| TO: | Jean Fraser, Planner | DATE: | 3/21/2018 |
| FROM: | Michael Guethle, PE; Ryan Wingard, PE | PROJECT NO.: | 13982A |
| SUBJECT: | Bramhall St. - 22; MMC East Tower and Visiting Parking (PEZ.2017.289) | | |

SHEET 6 OF 12

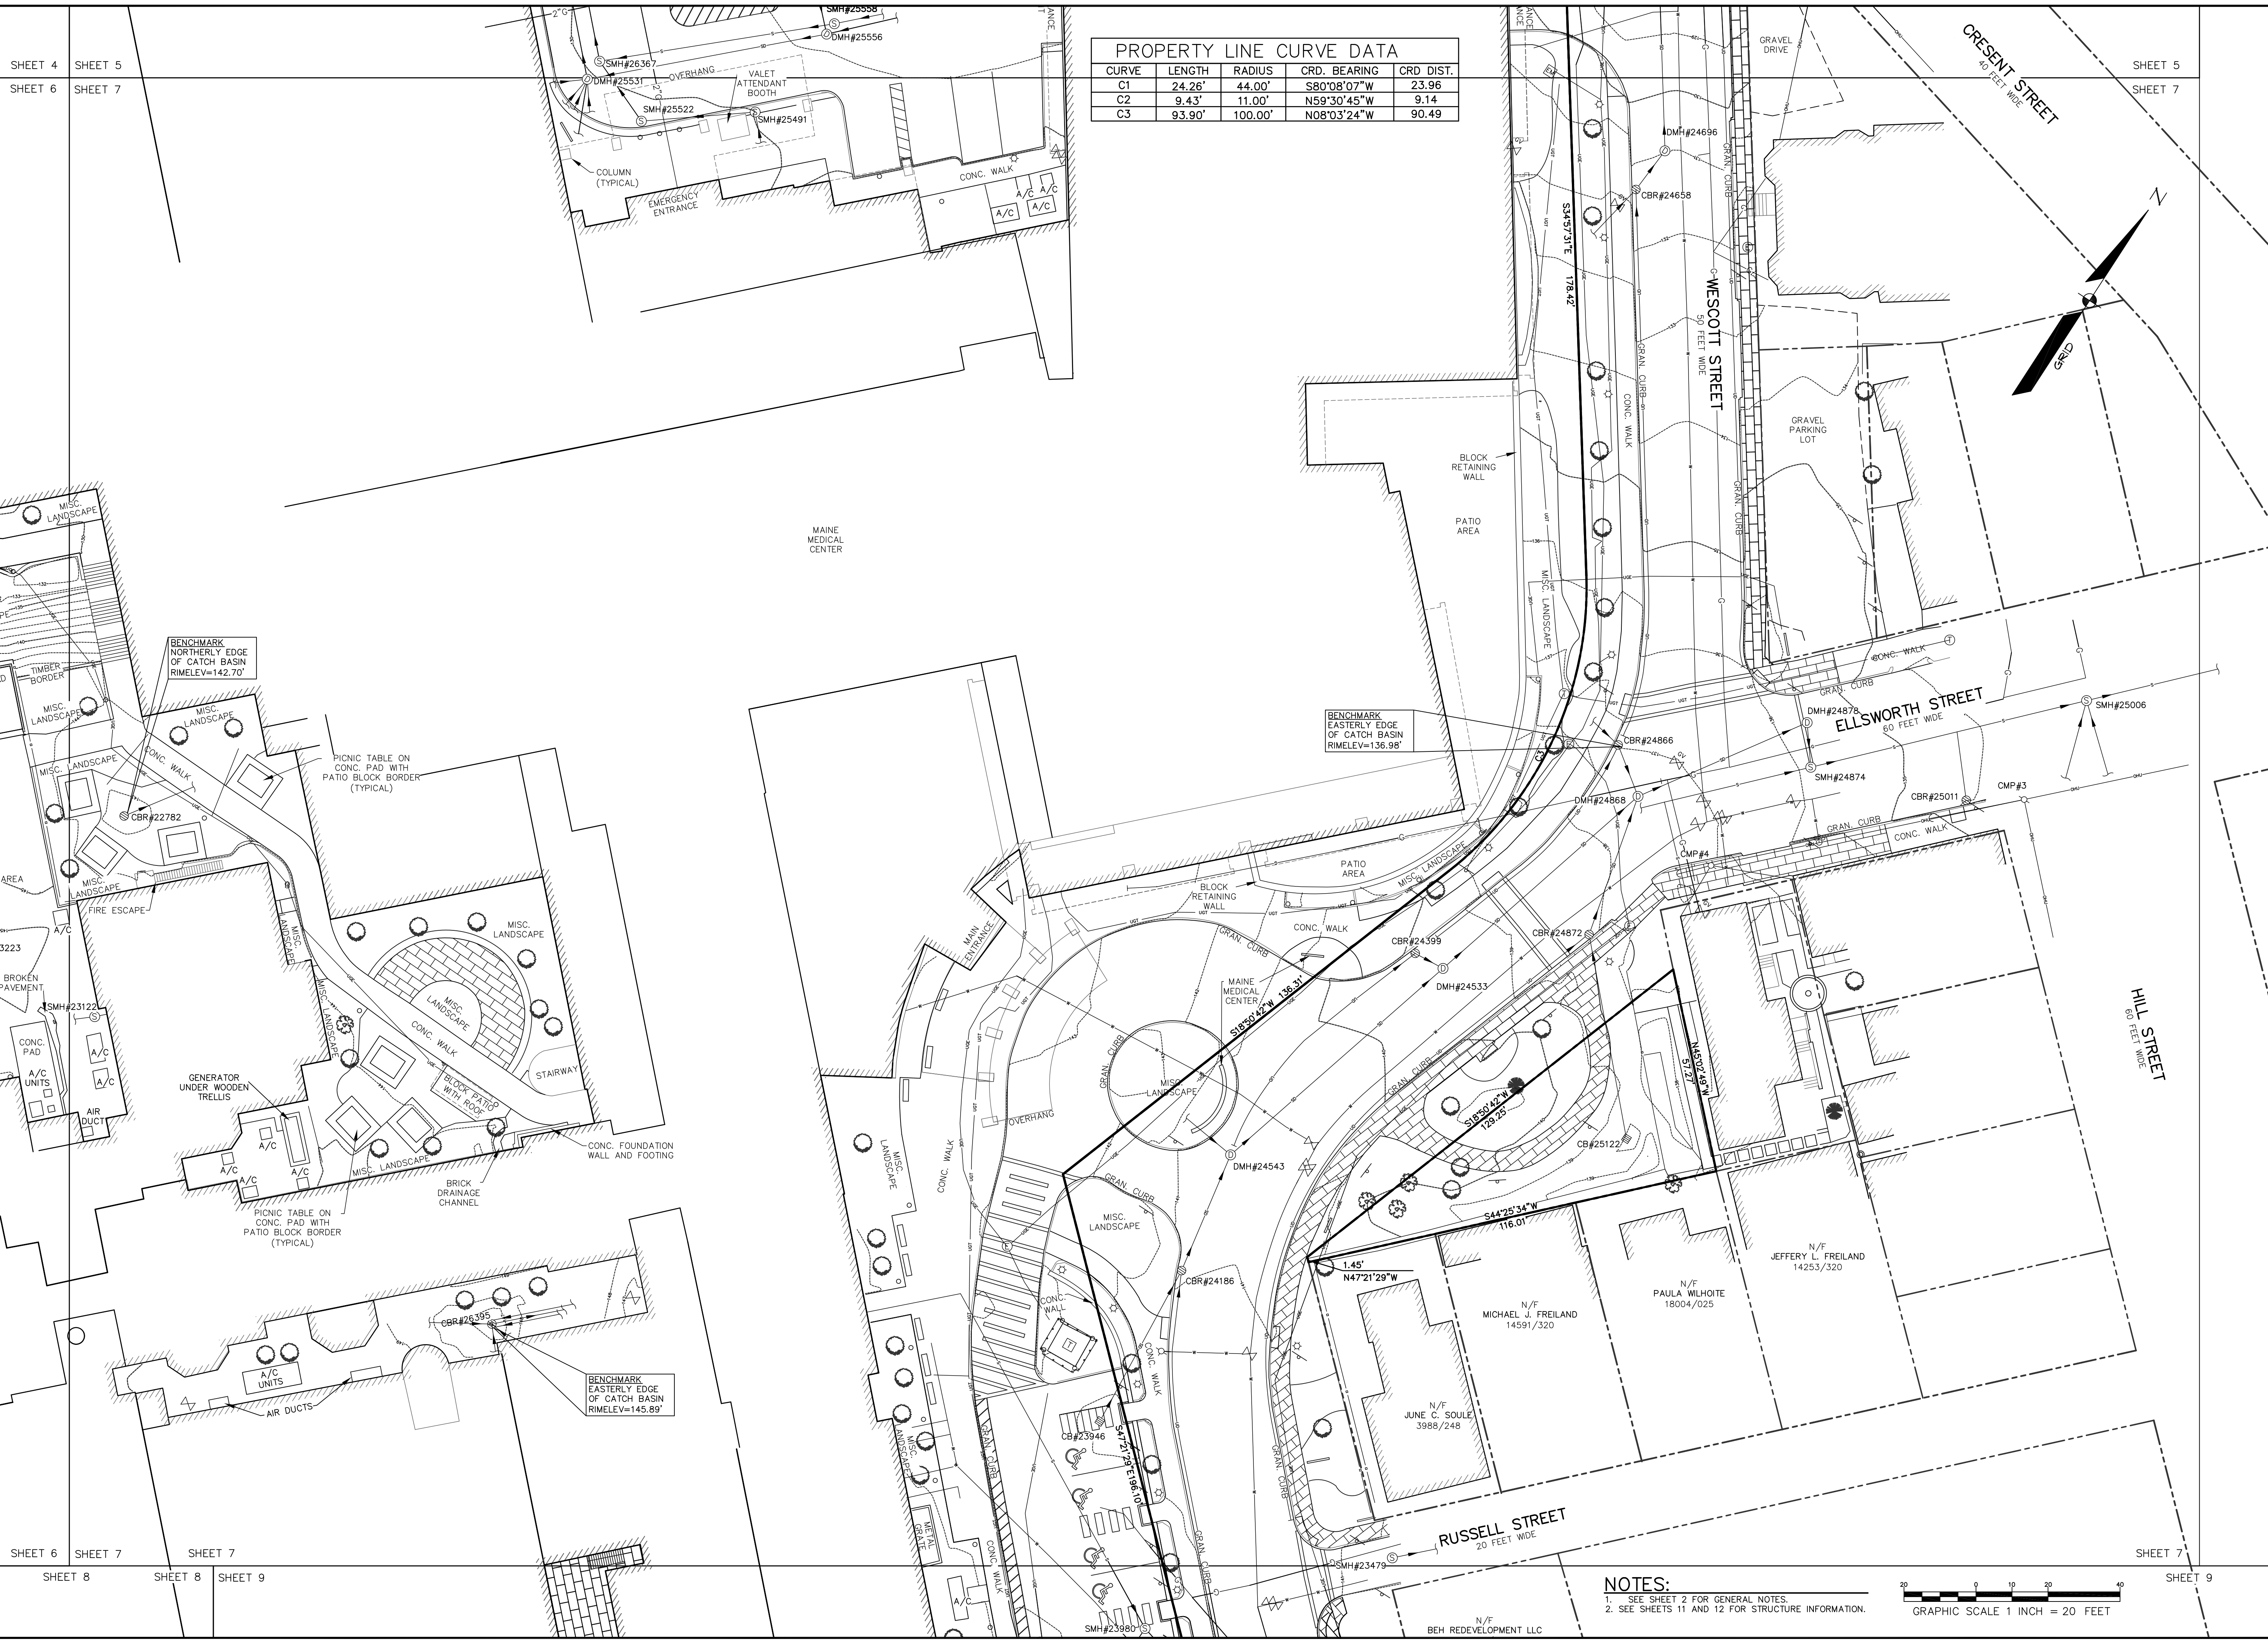
- ii. The applicant has provided an updated Boundary Survey. Associated with the updated boundary survey were certain details and descriptions of utilities within the project corridor, indicating their location adjacent to existing building locations and existing retaining walls with building supports.

- iii. Information was also provided confirming that two 6” pipes discharging into the existing separated storm system were discontinued sewer services from when the system was a combined sewer, and that these pipes terminate before the existing retaining wall. These pipes therefore are not ideal connections for a proposed roof leader.

- iv. A presentation was provided by the applicant and the applicant’s representative at the Public Workshop on 2/27/2018 that further reviewed the utility corridor. At this presentation, more information was provided indicating utility locations adjacent to existing buildings and existing retaining walls with building supports.
